Hyder Consulting Pty Ltd

7 February 2013

Barangaroo Central Waterfront Promenade and Interim Public Domain Works - Response to Submission from SPC

Barangaroo Headland Park Main Works (Marine) Tender Design Navigational Aids Drawings

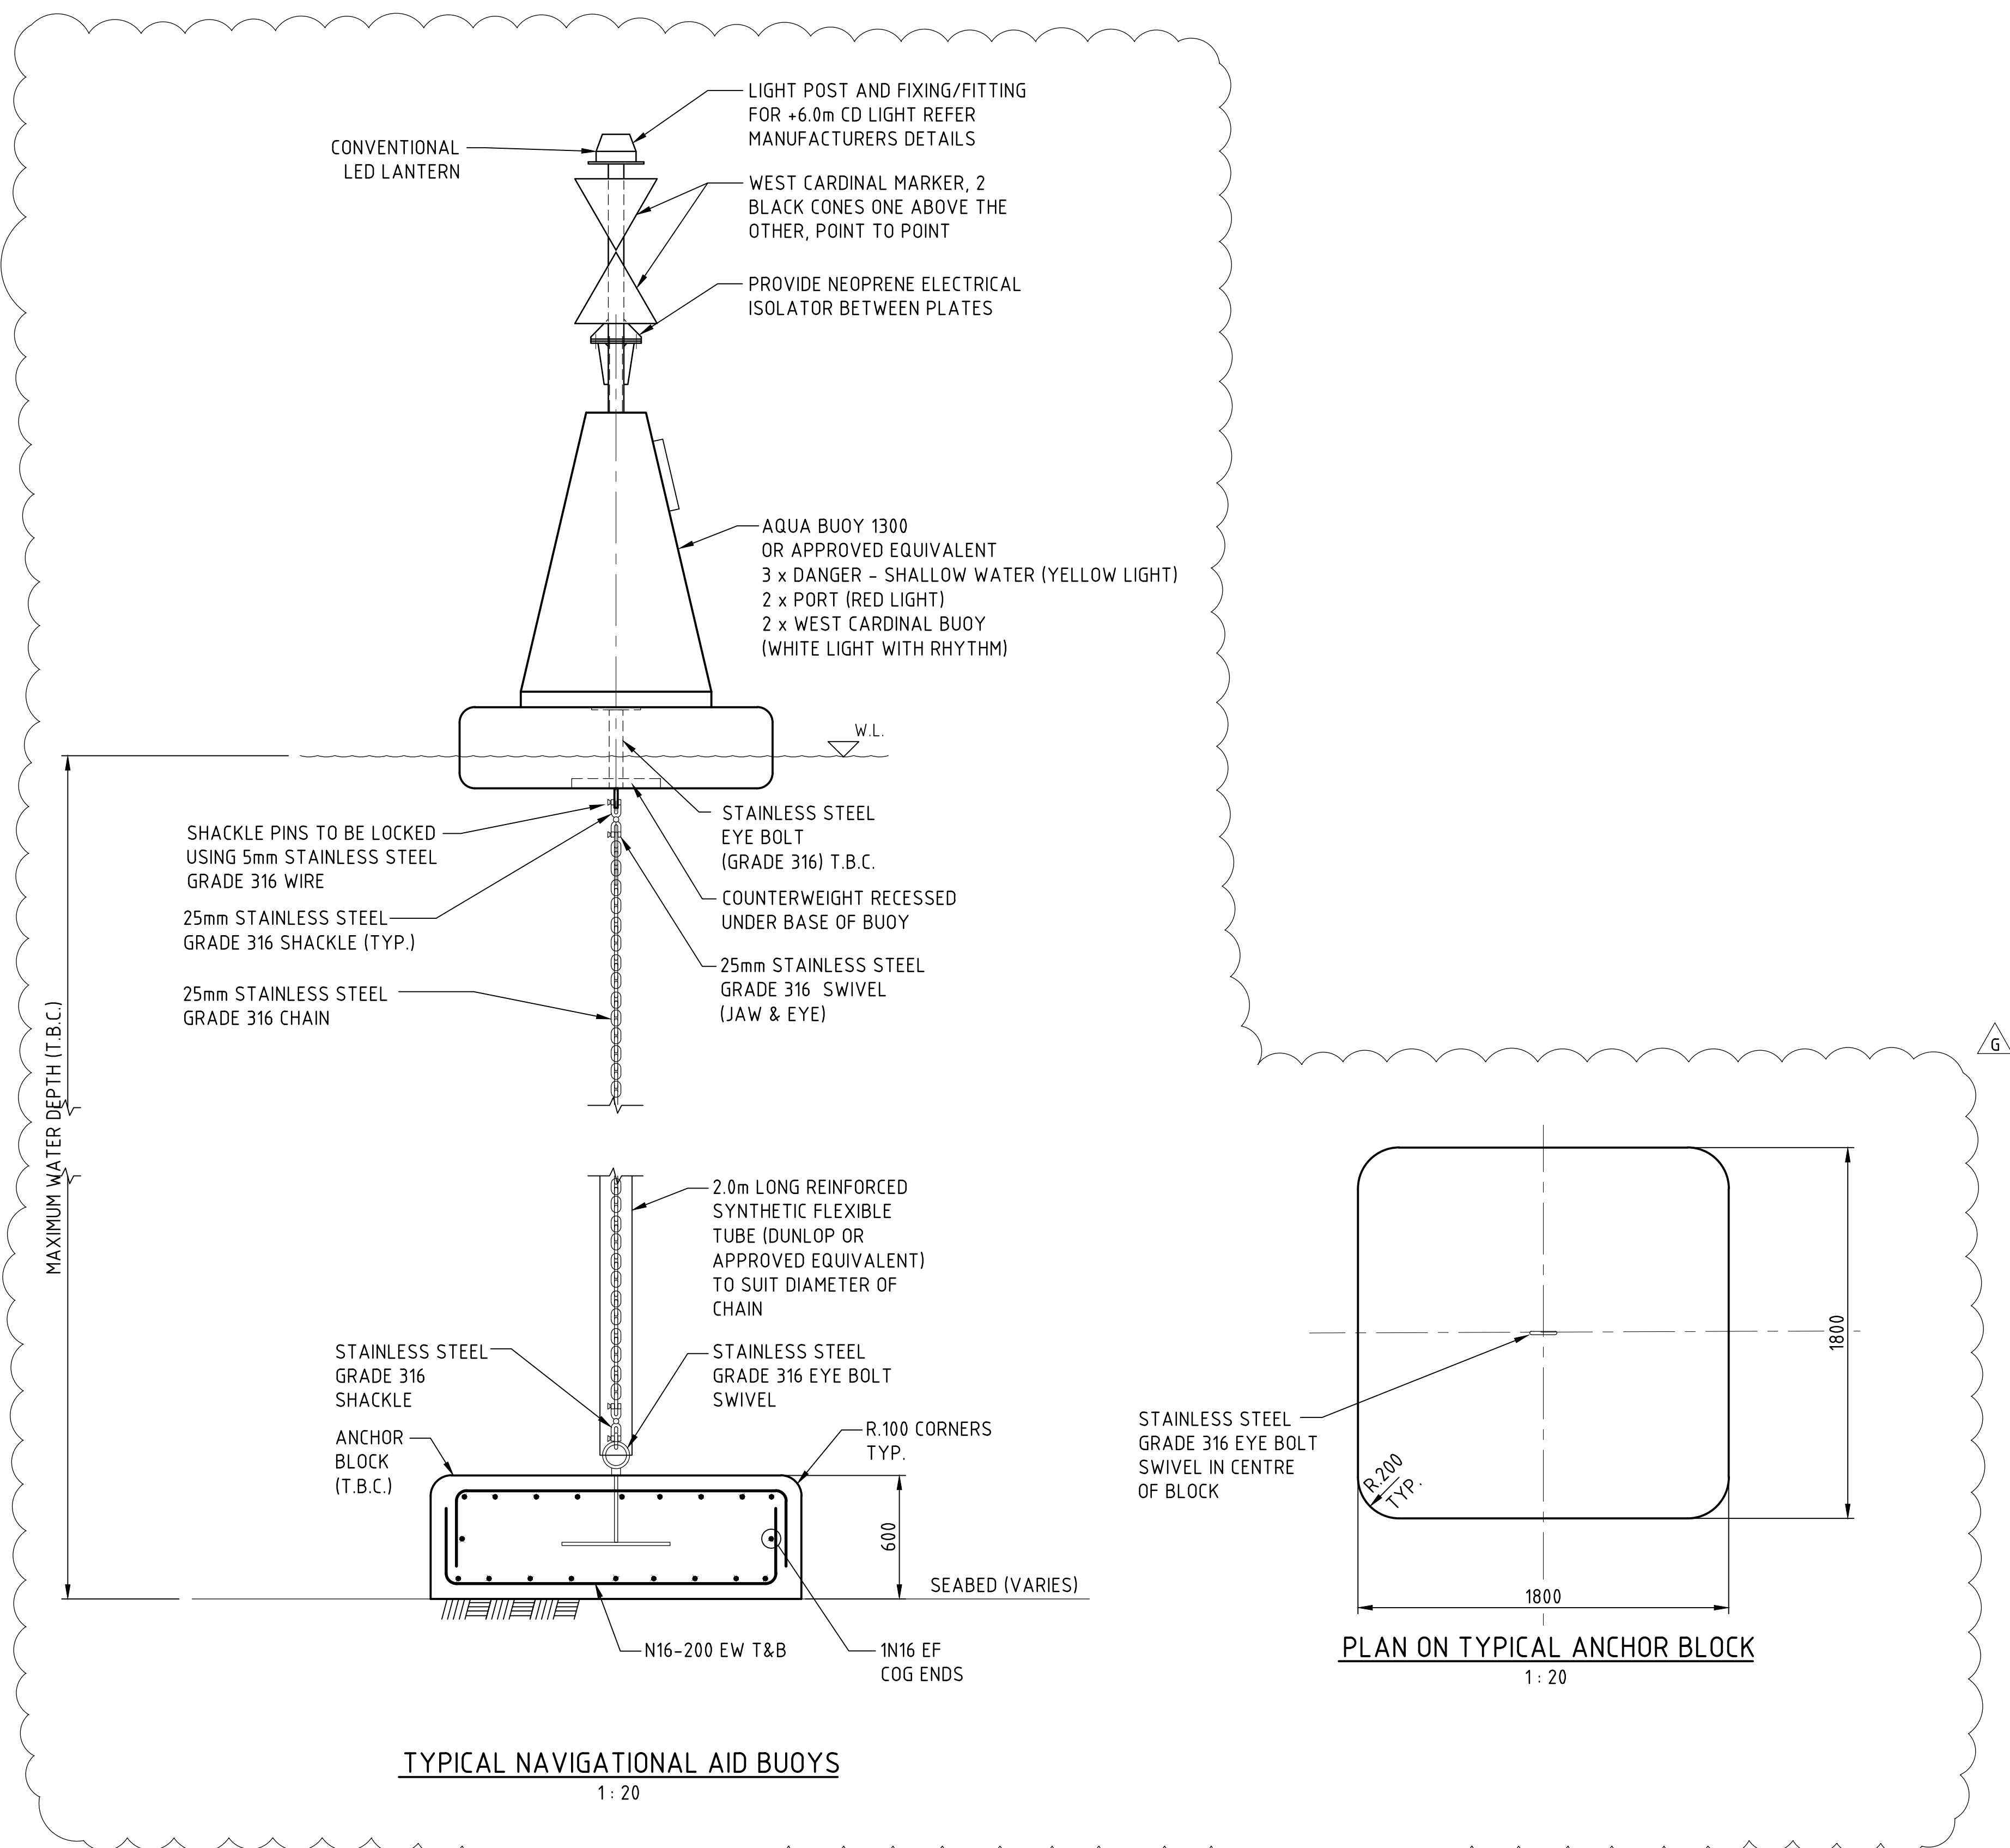
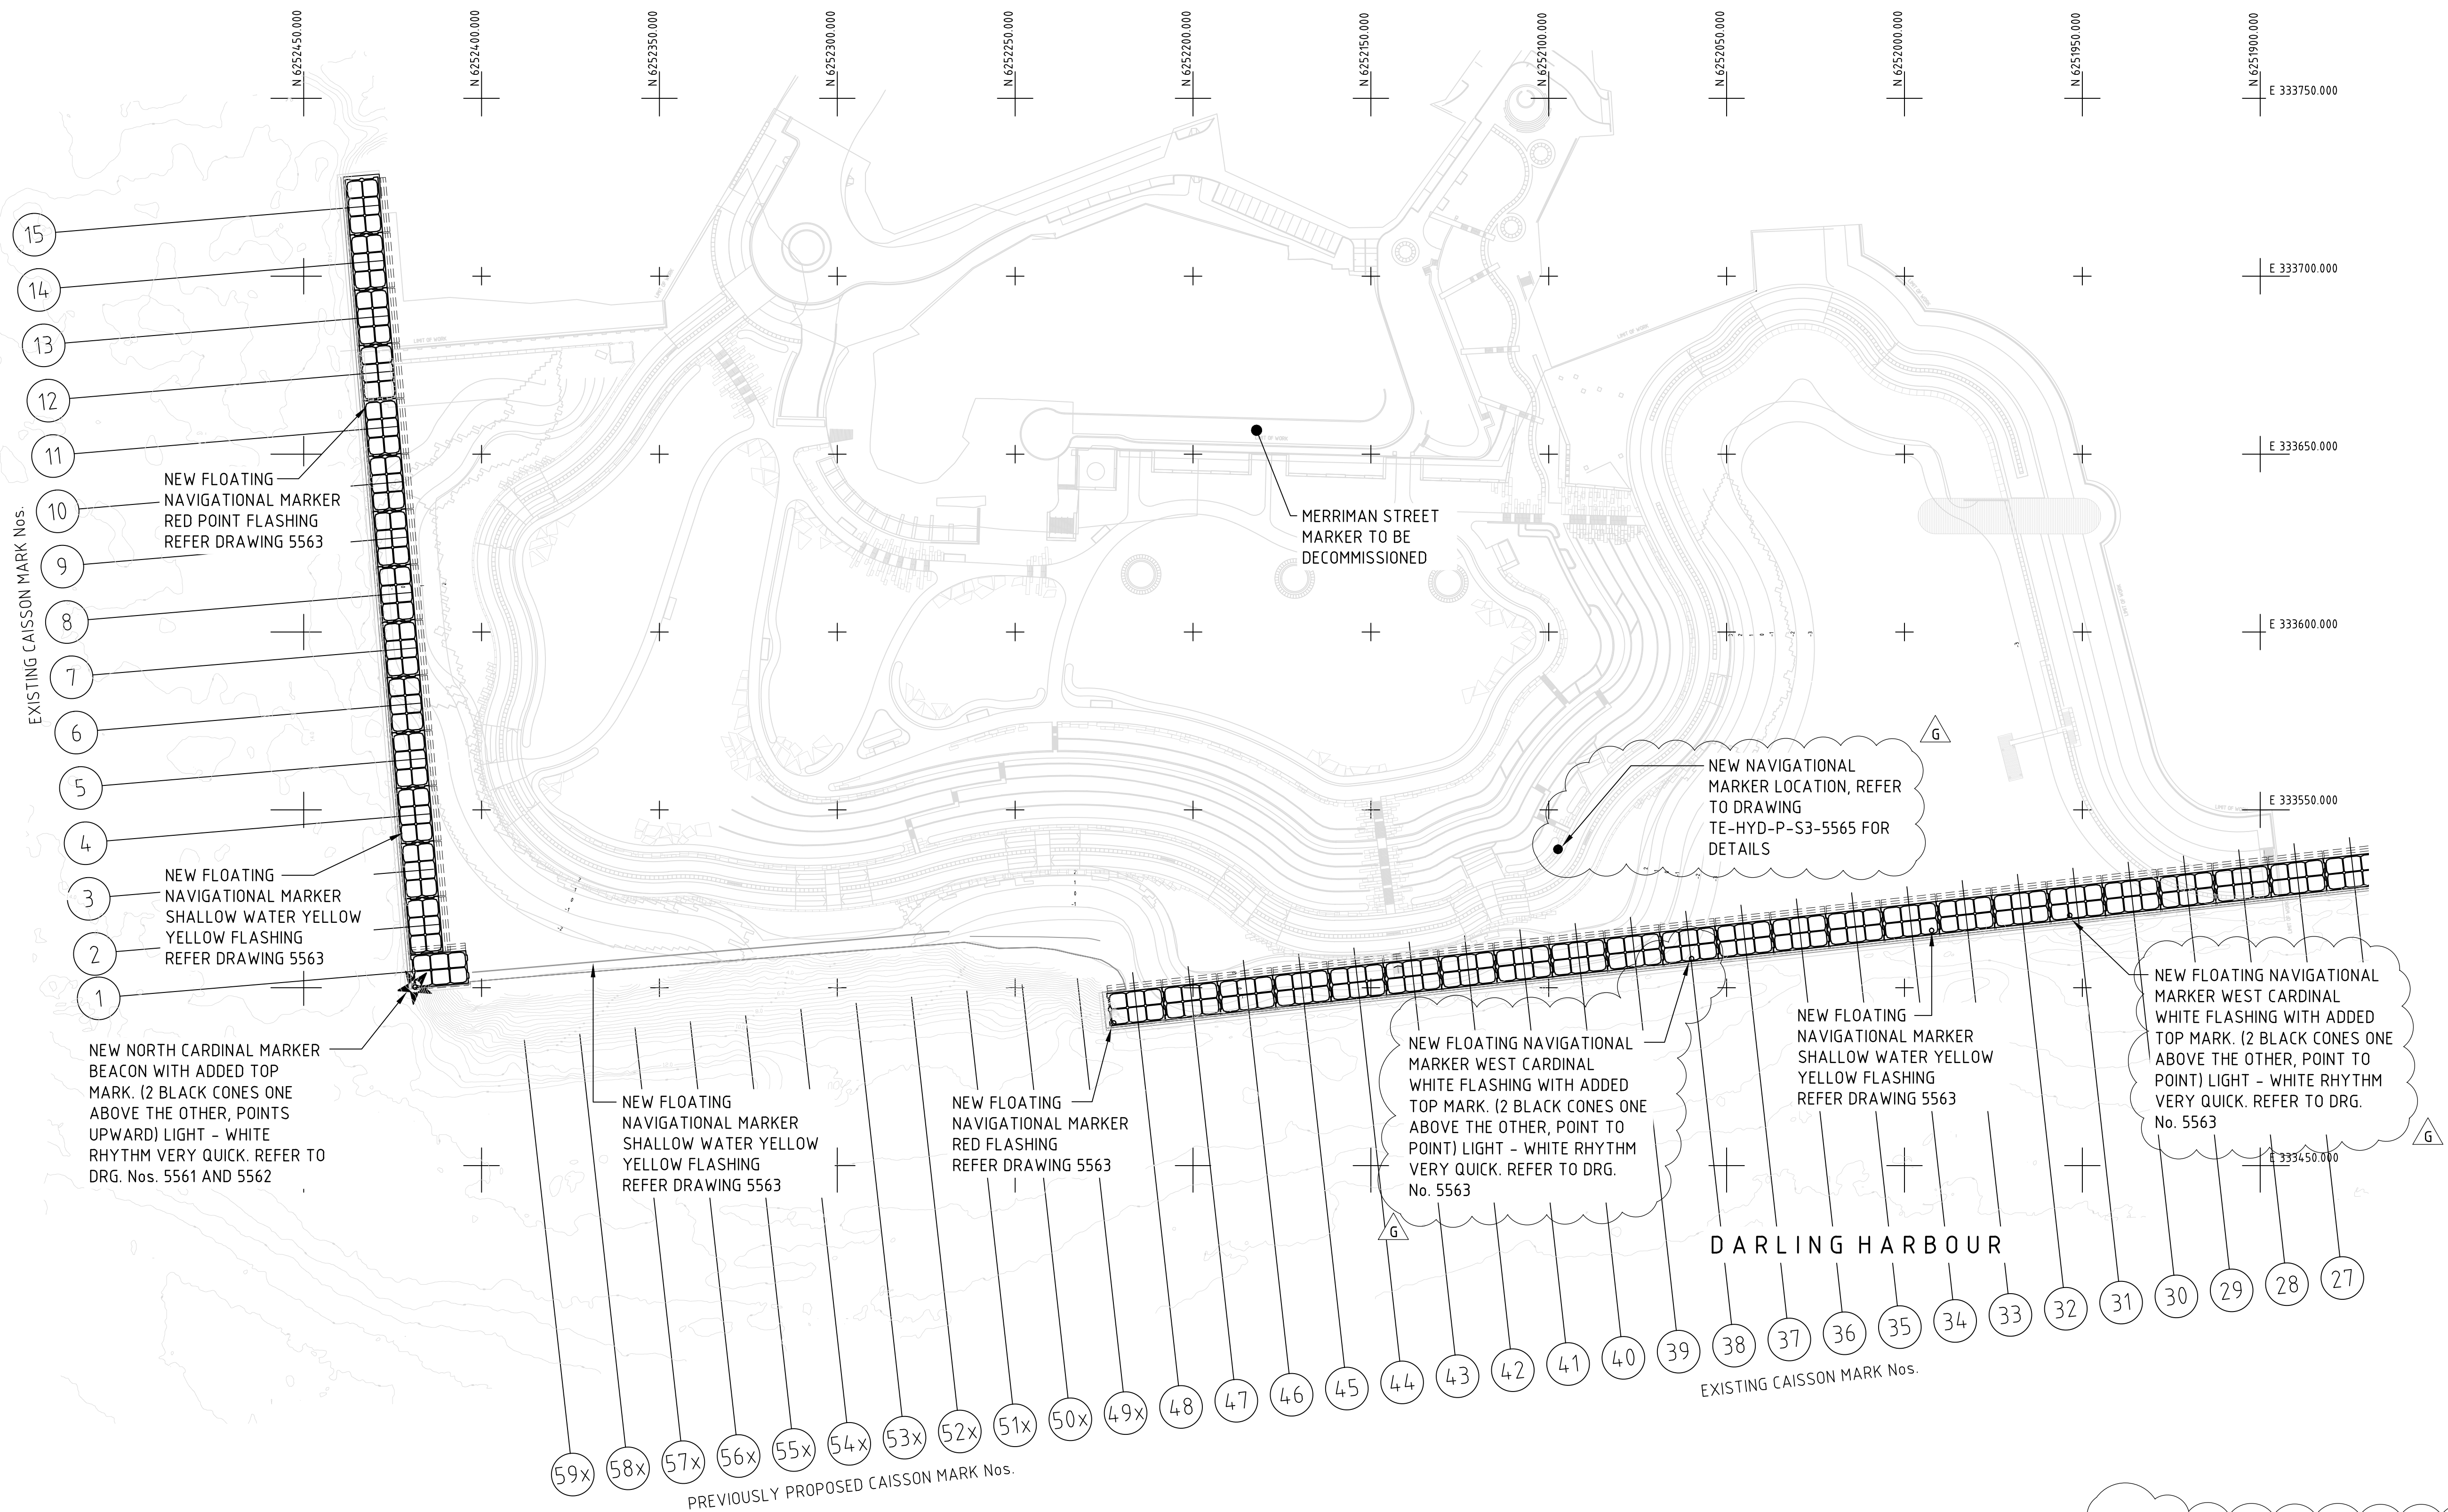
Appendix 13 (p10) – text regarding navigation aids is inconsistent with the drawing provided in Appendix B. The drawing in Appendix B has been discussed with the Harbour Master and it is Sydney Ports' understanding that works indicated within this drawing will be implemented. Confirmation of this should be provided by BDA.

Navigational aids for the Northern Cove as shown on TE-HYD-P-S3-5103-G in Appendix B have been confirmed and we have been advised by the contractor that these will be implemented, i.e. two new floating navigational mark west cardinals (white flashing) with added top mark and lighting (white rhythm very quick) located on the east and western side of the Northern Cove and a new floating cautionary marker for shallow water (yellow flashing) located at the centre of the Northern Cove mouth.
